SPR EA1N and EA2 PROJECTS

DEADLINE 12 – COMMENTS ON APPLICANTS RESPONSES TO EXQS3

Interested Party: SASES **PINS Refs:** 20024106 & 20024110

Date: 28 June 2021 **Issue:** 1

Figure 5: Outline Landscape Mitigation Plan and Relevant Heritage Assets in the vicinity of Friston

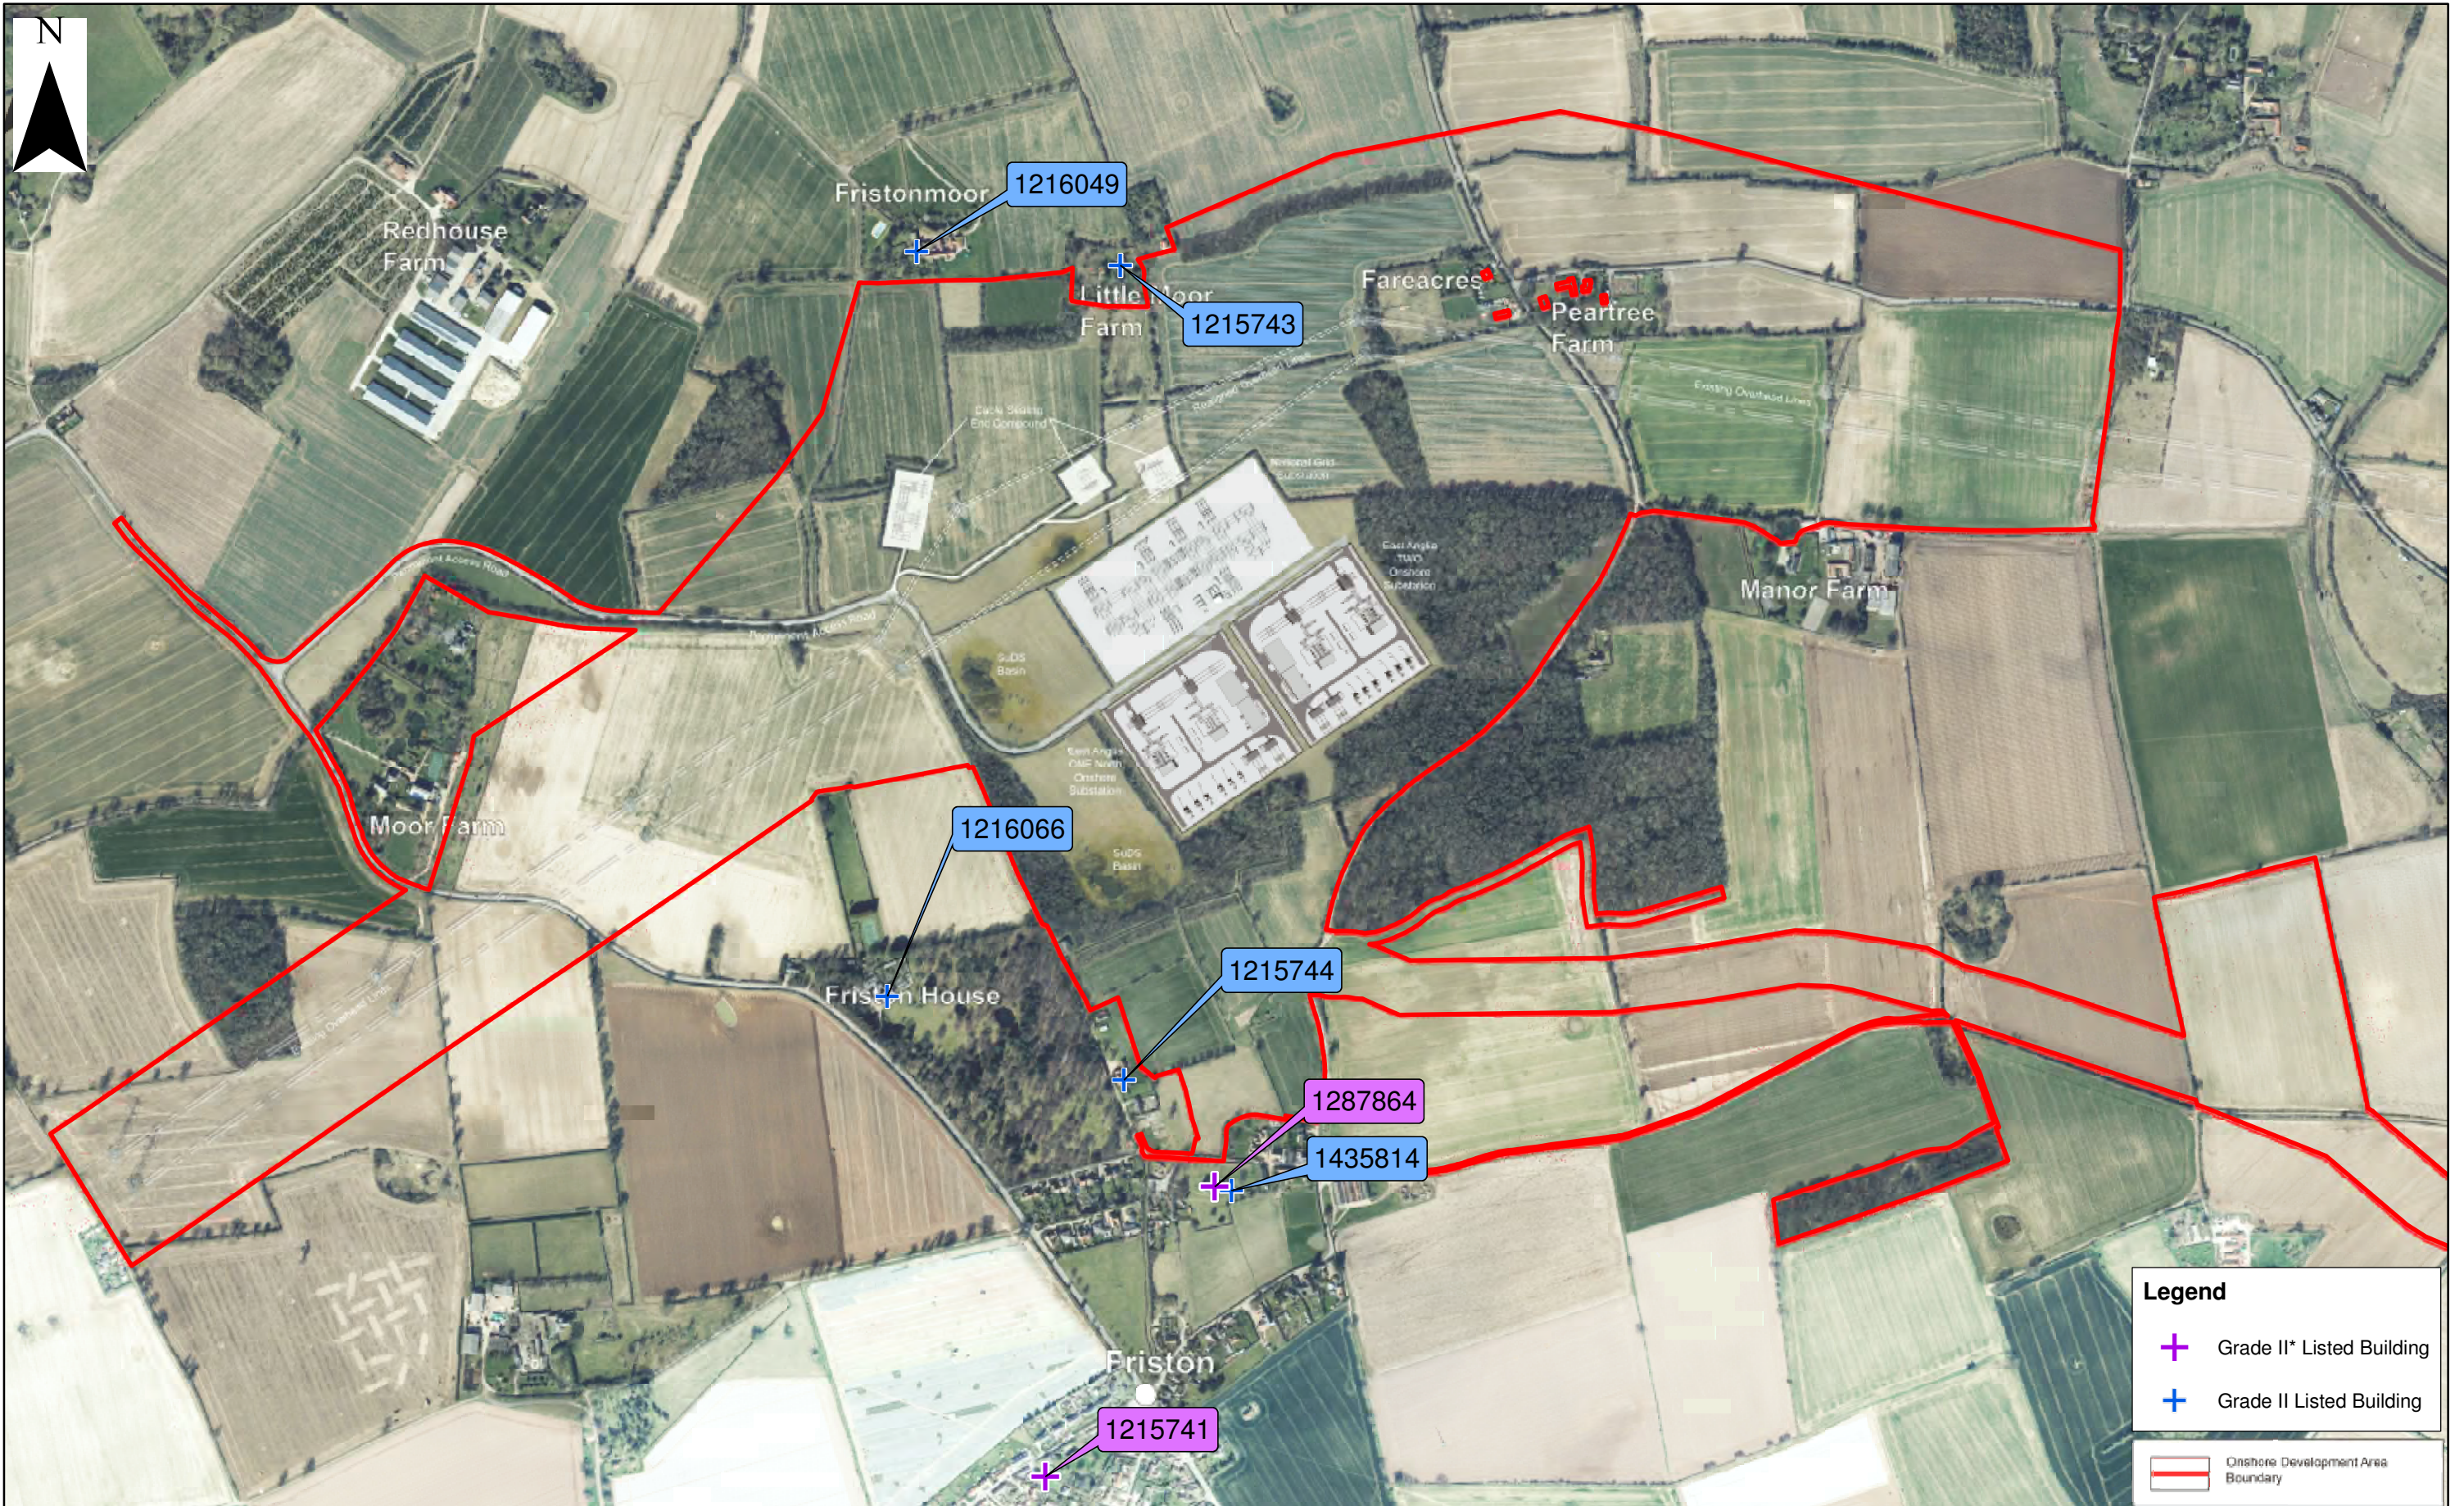
3.10.2	<p>OLEMS</p> <p>Your answer to ExQ2.10.5 [REP6-063] relates to planting and High House Farm. The ExAs note that you are seeking to balance the proposals in trying to not enclose historic farms while mitigating visual effects on people living in the area. Your answer states that the proposed planting close to the south western boundary of High House Farm is adjacent to existing woodland within the curtilage of this property. An annotated aerial photograph is submitted as part of the answer to demonstrate this point.</p> <p>However, the ExAs noted on their site visits [EV-007d, and as referred to in ExQ2.8.2] that the garden of High House Farm provided clear views across a largely open landscape to the Church of St Mary. This effect was increased by the removal of various ash trees in recent times due to disease [referenced in EV-007d] which would likely change the aerial photograph were it to be taken now.</p> <p>Given this do you wish to add to your answer ExQ2.10.5?</p>	<p>The Applicants agree that the OLEMS (REP10-005) includes planting proposals adjacent to the southern boundary of the grounds of High House Farm. The new planting area proposed by the Applicant close to the south western boundary is proposed to provide additional screening of views to the south where the sealing end compounds will be sited.</p> <p>The Applicant notes the recent removal of various ash trees due to disease, which has resulted in more open views than at the time of the original assessment. The Applicant noted a mature vegetated boundary to the south-west of the property near Landscape Visual Impact Assessment (LVIA) Viewpoint 5 during its site survey work in the area in February 2019 (see photo below), which it considered would provide some screening and a basis from which to justify further planting around this boundary.</p> <p>It is clear that trees were located to the south of the farm both historically</p>	<p>In the question the ExAs identify that <i>'the garden of High House Farm provided clear views across a largely open landscape to the Church of St Mary.'</i></p> <p>Vp 5 shows a similar open view across to the church as that from High House Farm. In response to ExA question 3.10.2, SPR's justification for enclosing this view by planting appears to be that <i>'The Applicants recognise that this will have to balance various interests.'</i> It is unclear how <i>'consultation with local residents ... to discuss their expectations for landscape work in the vicinity of their properties'</i> can address this issue satisfactorily.</p> <p>The severity of the impact on the views from High House Farm is a consequence of the severance that the development will cause between the historic farmhouse to the north and the village and its church to the south. As previously identified, this is a visual severance (as evidenced from Vp 5), a physical severance (the substations/sealing end compounds will lie between the</p>

<p>(OLEMS Figure 1 (REP10-005)) and recently until their felling due to decline as a result of Ash dieback. Such trees would have prevented or filtered views to the south. The proposed woodland area alongside this would seem to be an appropriate bolstering of such a design intent however, the Substations Design Principles Statement (document reference ExA.AS-6.D11.V3) sets out that consultation with local residents will be undertaken to discuss their expectations for landscape work in the vicinity of their properties and this will be taken into account subject to agreement with other stakeholders. The OLEMS has been designed in outline to ensure that an appropriate framework is delivered. The Applicants recognise that this will have to balance various interests. It is important that there is a proper process to enable this to be done in a transparent way. The design process secured through the draft Development Consent Order (DCO) will facilitate this.</p>	<p>farmhouse and the village) and a severance of connection (the historic route between the village to the farmhouses will be permanently lost).</p>

## **Figure 29.37**

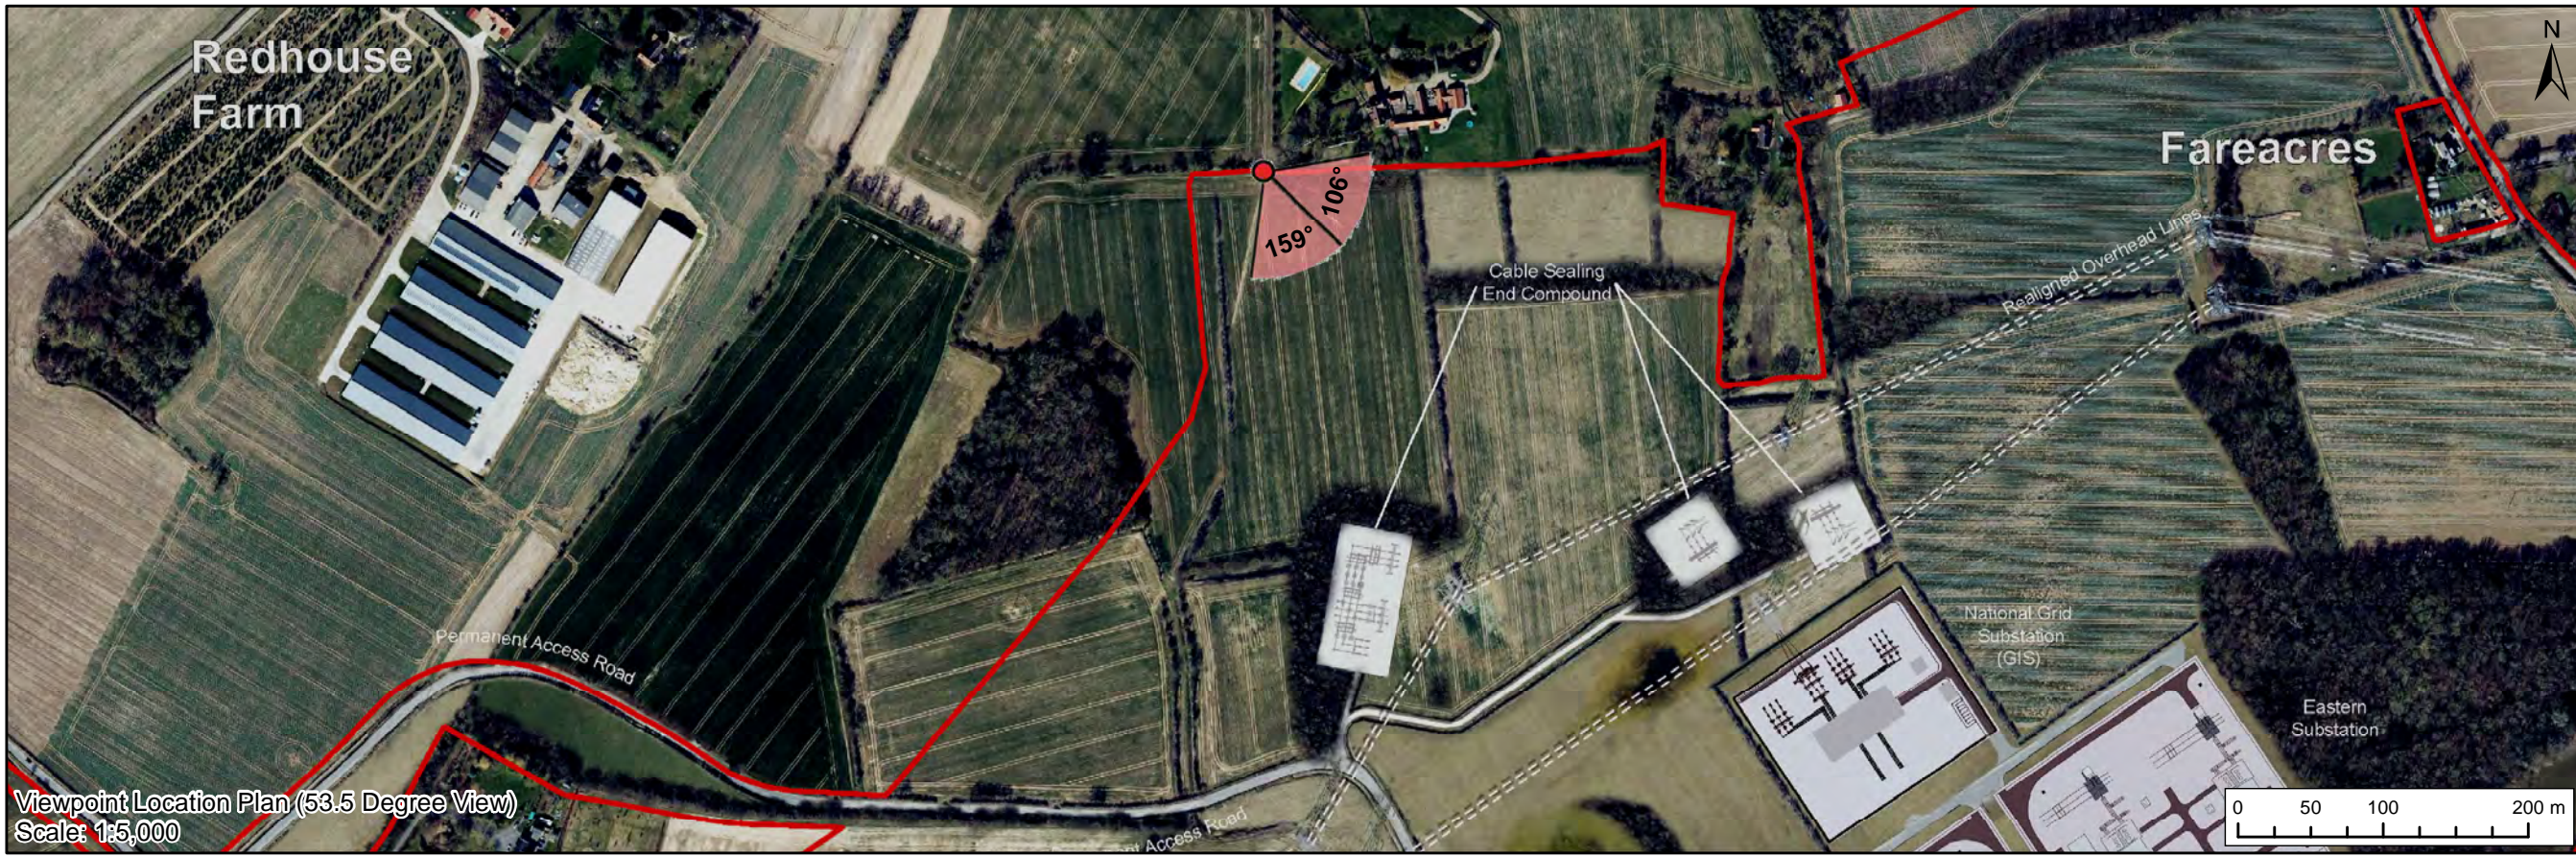
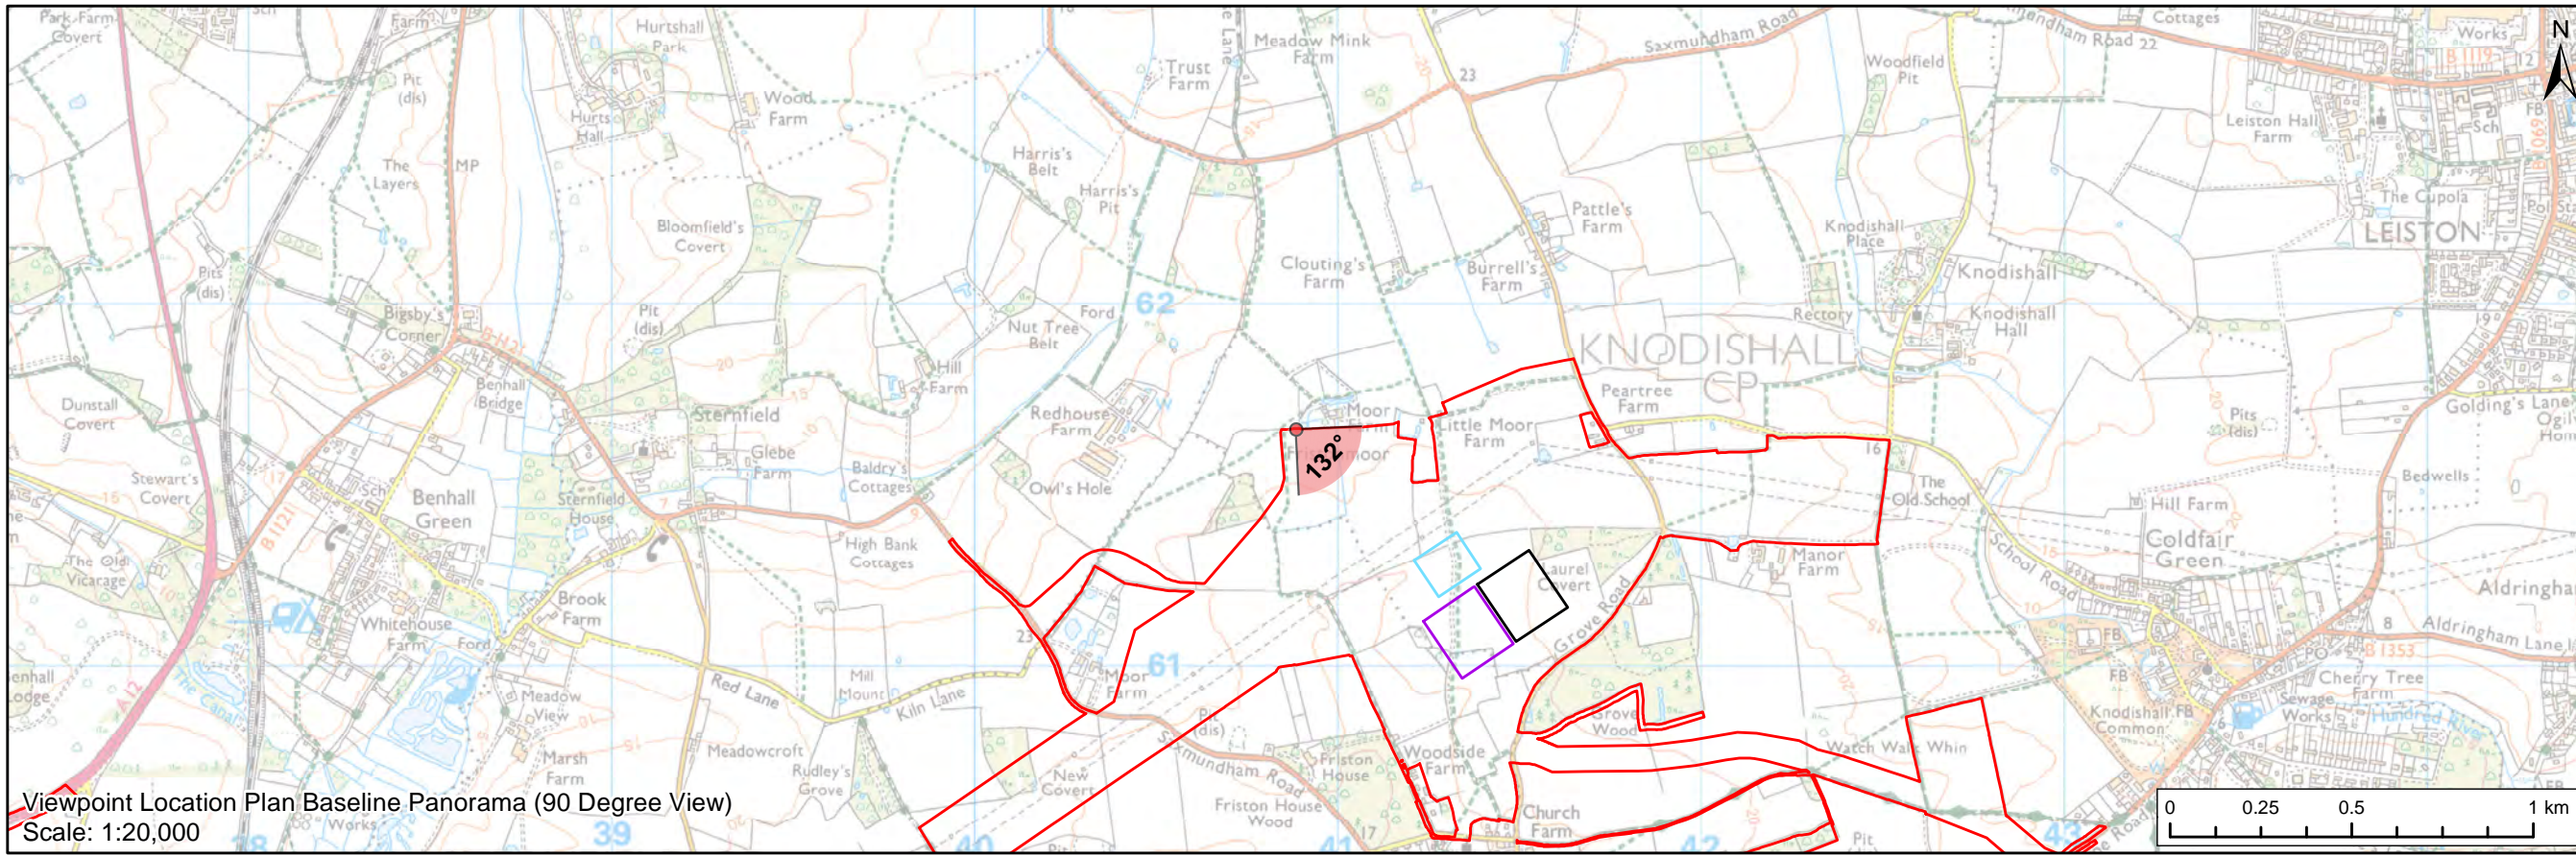
3.10.3	<p>Combined effect of pylons and proposals</p> <p>Pylons are often referred to as ‘marching across the landscape’, which partly could</p>	<p>The influence of the existing double rows of pylons and overhead high voltage lines can be seen clearly in Viewpoint 5 Figure 29.17a (document reference ExA.AS-4.D11.V1) in which</p>	<p>The only explicit reference to the harm that would be caused by the additional pylon is in response to the ExA question 3.10.3¹. As previously set out SASES consider that the</p>

<p>be a consequence of their height and form but also due to the open frame of the pylons themselves and the space that remains beneath them. SASES [REP6-133] state that the proposals would have the effect of making the pylons more dominant than they currently appear, due to the change in the landscape around them that the proposals would cause with an open rural landscape being replaced by a more industrial one.</p> <p>Respond to the above point.</p>	<p>they cross the landscape between Friston and High House Farm at close proximity. With reference to the photomontages from the same view in Figure 29.17b, the Applicant considers that to some extent the proposed substations may draw further visual attention to the electrical infrastructure, increasing the legibility of the function of the pylons/transmission lines in the landscape, however it does not consider that the substation proposals would render the existing pylons more dominant than they currently appear.</p> <p>The loss of open agricultural landscape as a result of ground level infrastructure is recognised, however this does not increase the visual influence of the existing double row of pylons, which already have a prominent influence traversing the landscape between Friston and Fristonmoor.</p> <p>It is the presence of the additional pylon in the view towards Friston (next to the larger sealing end compound with circuit breaker) which is more likely to contribute to increasing the visual influence of overhead pylons in the local landscape.</p>	<p>proposals would have the effect of making the pylons more dominant than they currently appear. Although SPR are reluctant to accept this point they do acknowledge that <i>'the proposed substations may draw further visual attention to the electrical infrastructure, increasing the legibility of the function of the pylons/transmission lines in the landscape.'</i> They have also accepted <i>' the presence of the additional pylon in the view towards Friston (next to the larger sealing end compound with circuit breaker) will contribute to increasing the visual influence of overhead pylons in the local landscape.'</i> SASES consider that this is in effect accepting that the proposals would have the effect of making the pylon line (which would include the additional pylon) more dominant than they currently appear.</p>
